NORFOLK BOREAS

Oulton Parish Council's response at deadline 6 to the Applicant's response to written questions at deadline 5

Co-ordinate system: British National Grid EPSG: 27700

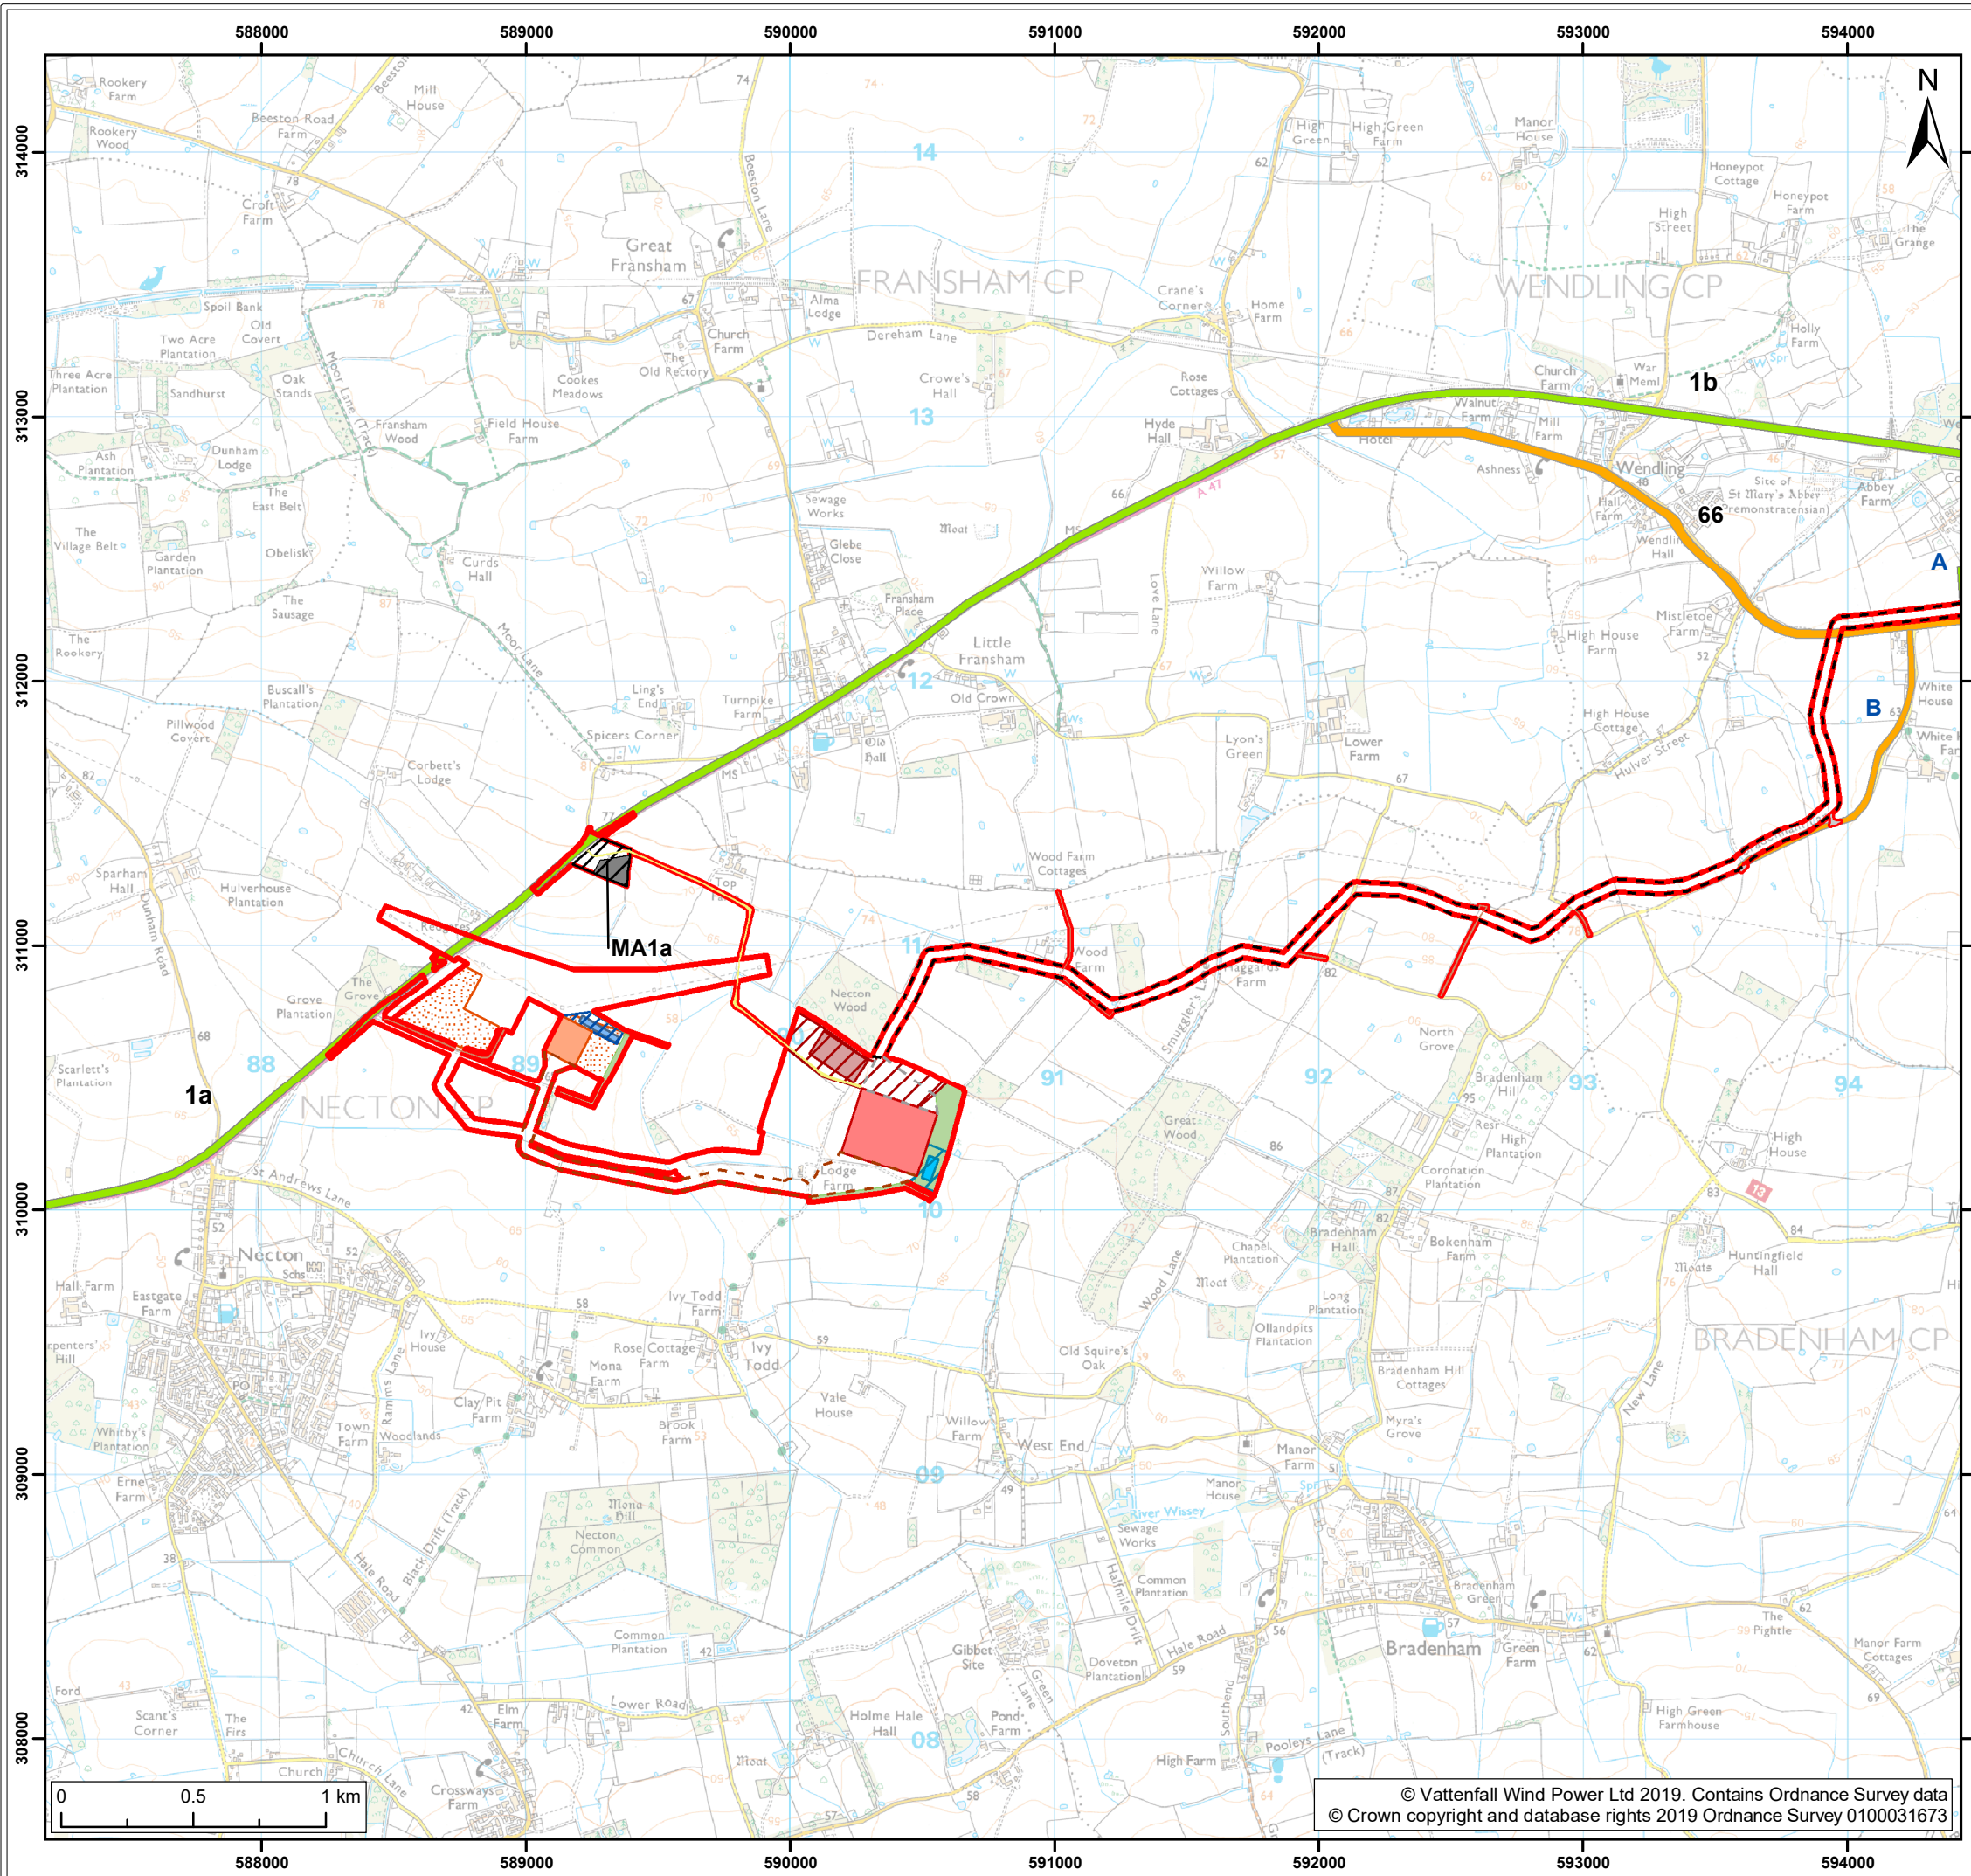
The assessment established that Link 68 has no national, regional or local designation as a cycle route/walking route and therefore is not a sensitive link with respect to those user groups. Therefore, the mitigation proposed for Link 68 was not specific to NMU but developed for all modes. ”

OPC note that the Applicants have dismissed Link 68 as a cycle route, as it is not designated. This is incorrect and extremely misleading. It should be noted that Link 68 is used by many individual cyclists, often by cycling clubs from near and far, doing a circuit from Aylsham or Norwich, and those who wish to join up with the Blickling Cycle route, along with Itteringham village shop/cafe off Link 75. It is also seen as a “safe” circular route for joggers, families with young children cycling out informally from Aylsham - across Abel Heath, along Heydon Road, up Oulton Street and back via Aylsham Road.

In fact, there are 3 designated cycle routes (figure1-3) that pass either along or near Oulton Street.
